REQUEST

Current Zoning: ML-2 (manufacturing and logistics, 2)
Proposed Zoning: MUDD-O (mixed-use development, optional)

Approximately 0.96 acres located at the southeast intersection of Thrift Road and Jay Street, north of Freedom Drive.

PROJECT: LUCKY DOG BARK AND BREW- 2220 THRIFT ROAD CHARLOTTE, NC 28205
 PETITIONER: LUCKY DOG CHARLOTTE PROPERTY, LLC
 15928 HENRY LANE HUNTERSVILLE, NC 28078
 SHEET TITLE: EXISTING CONDITIONS CONDITIONAL SITE PLAN
 SHEET: L1 OF 1

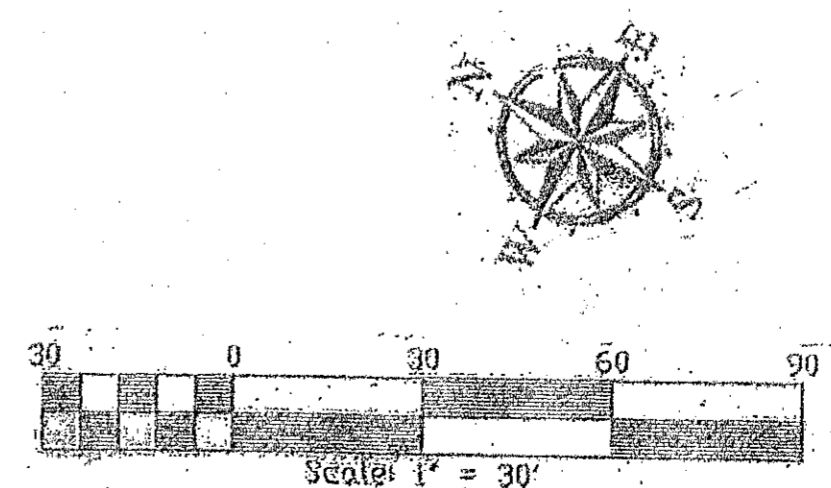
- ~~1. Include the minimum number of parking spaces that would typically be required on the site without the optional provision in addition to the listed number of parking spaces that will be provided with the optional provision.~~ **Addressed**
-
